Mark E. Jones, PE
Structural Engineering and Design

Ref: Site Observations and Analysis
180 Pondhurst Ln.
Fuquay-Varina, NC
Permit No. SFD2403-0035
Project No. 22-037

**FIRST FLOOR PLAN**  
CEILING HT. = 9'-0" 1/4" = 1'-0"

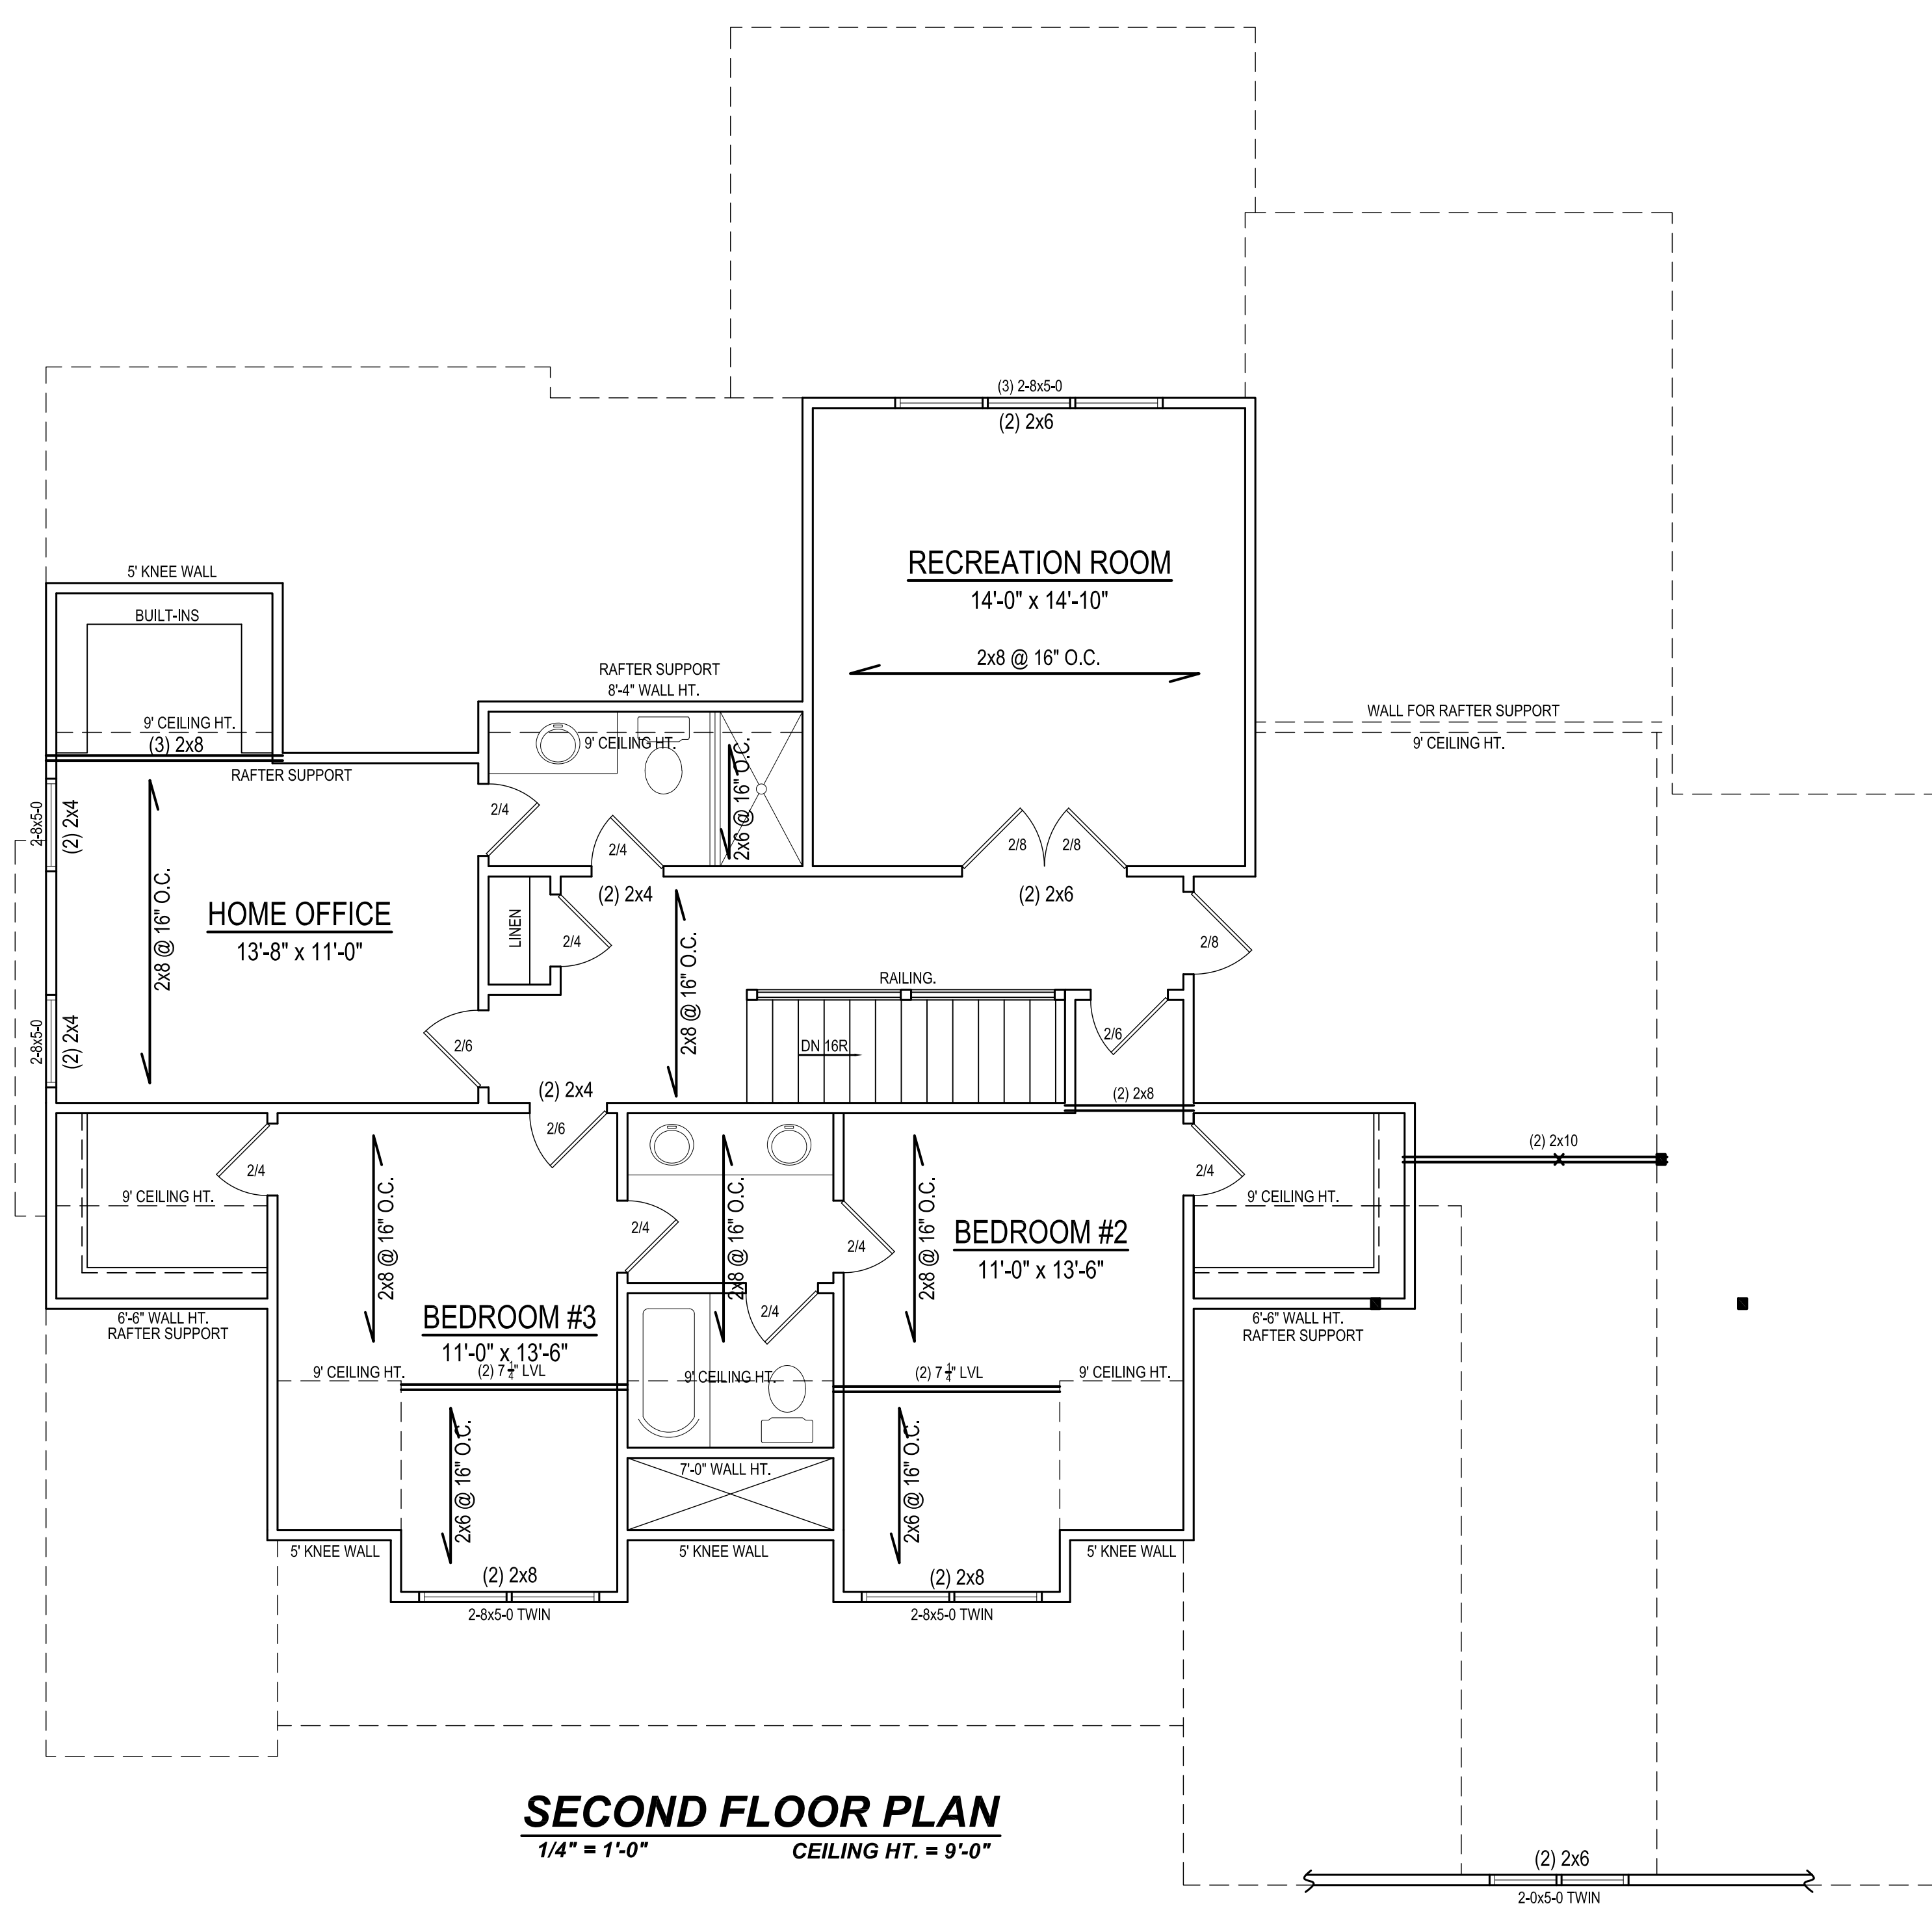
1. The builder has provided a 12' wide rear door in lieu of the plan specified 15' wide door. The 3-ply 11 1/4" LVL header installed is adequate to support all imposed design loads. No further action is required.
3. The plan specified extra joists were indicated to provide at least one joist in the locations shown (master bath and master closet). The I-joist layout shows the required joists, and the builder has provided them as specified. No further action is required.
